Saxlingham Nethergate Parish Council

Written Representations submitted in response to East Pye Solar

PINS Reference: EN0110014

Land Parcels 7D and 7F

Figure 11.4: Likely and Suitable Routes to the Scheme
Sites 4, 5, 7A-F
Revision A

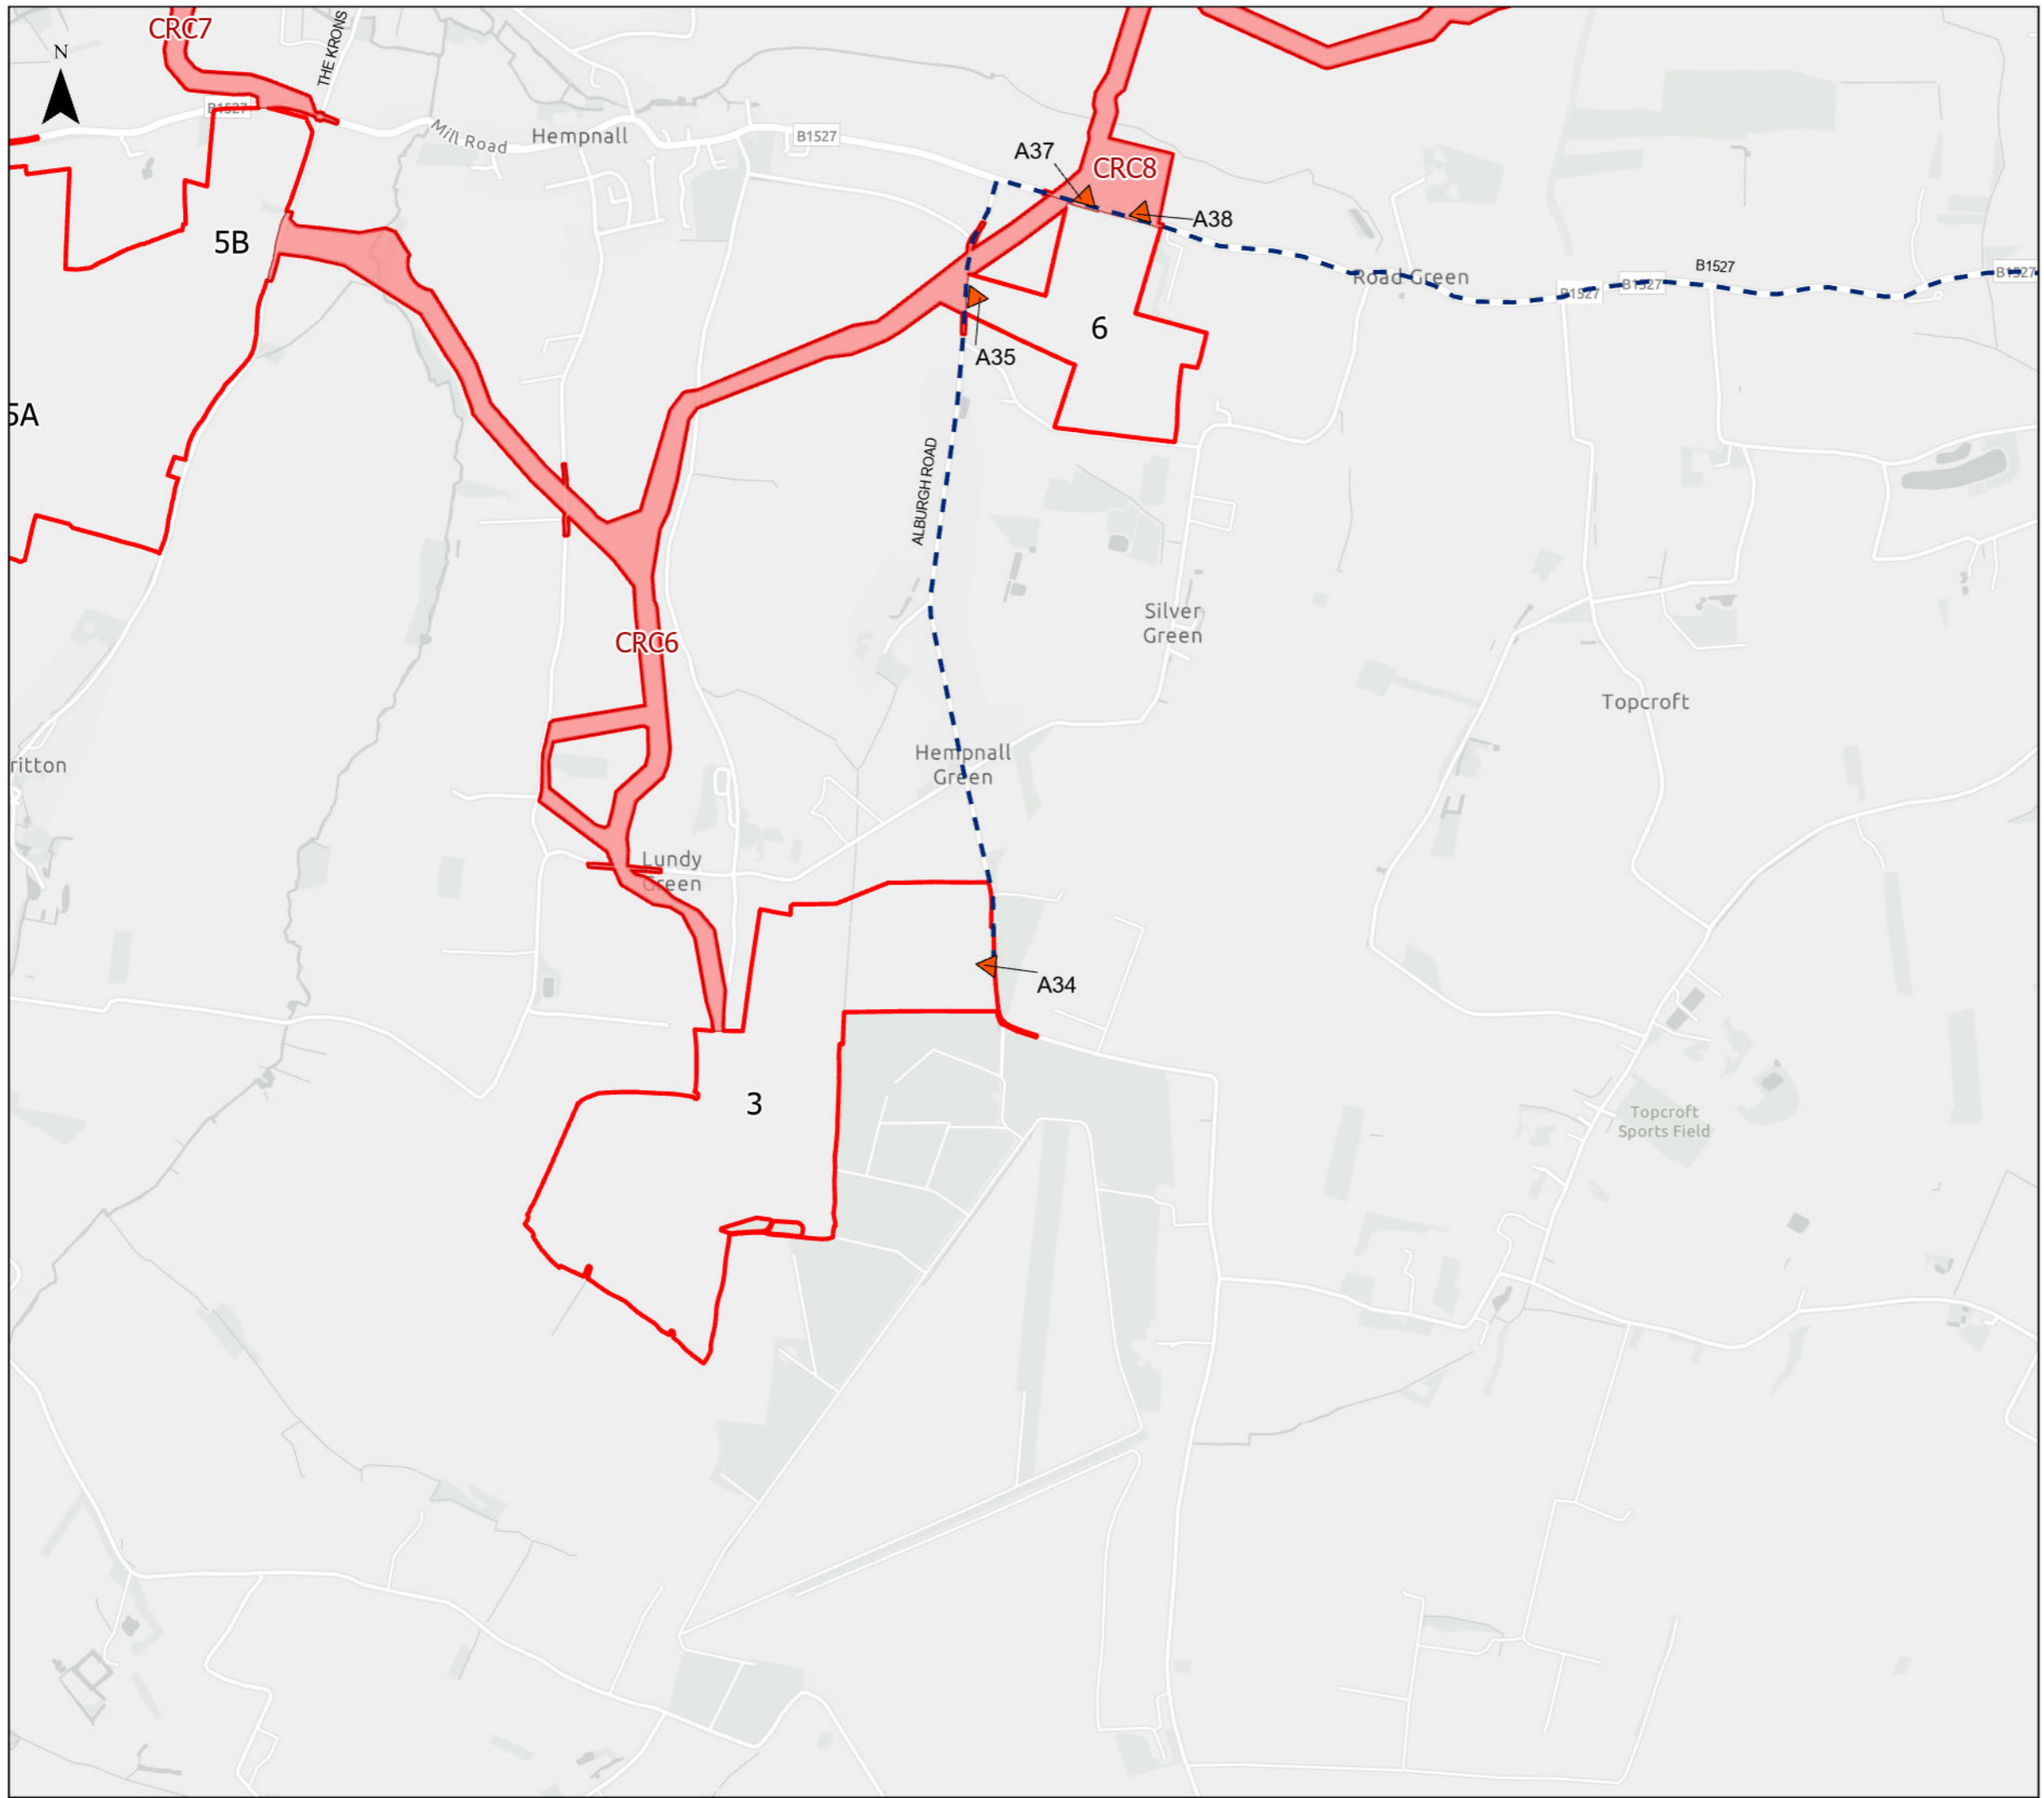
- This flaw affects Site 7 as much of the haulage will be held at Site 4A before called on to Sub-site 7A-F impacting the Hempnall roundabout and causing congestion and road user risk;

- **Site 4A will act as a holding point for haulage to be called on to 7A-7F;**
- Norfolk County Council refused access to Sites from A-roads yet and anything less than a B-road. This access point is not just from an A-road but also a **major junction on the A140;**

- **A19 accesses a major construction Compound and haulage holding site for 7A-7F** which will cause further congestion at the roundabout;
- Access to the haul road for Site 7 is from a C-road;

- Many lanes and access points haven't been surveyed including the junction with Brick Kiln Lane and B1527 which will serve haulage to site 7A-7F;
- Visibility splay at access points cannot be achieved without removing significant habitat like wooded areas and hedgerows;

- The transport route to haulage route 7A-7F is via the Krons, a lane not meant for heavy haulage and no assessment has been made of the brick bridge over the Hemphall Beck (described as insignificant). East Pye Solar report that no weight limit signs are visible
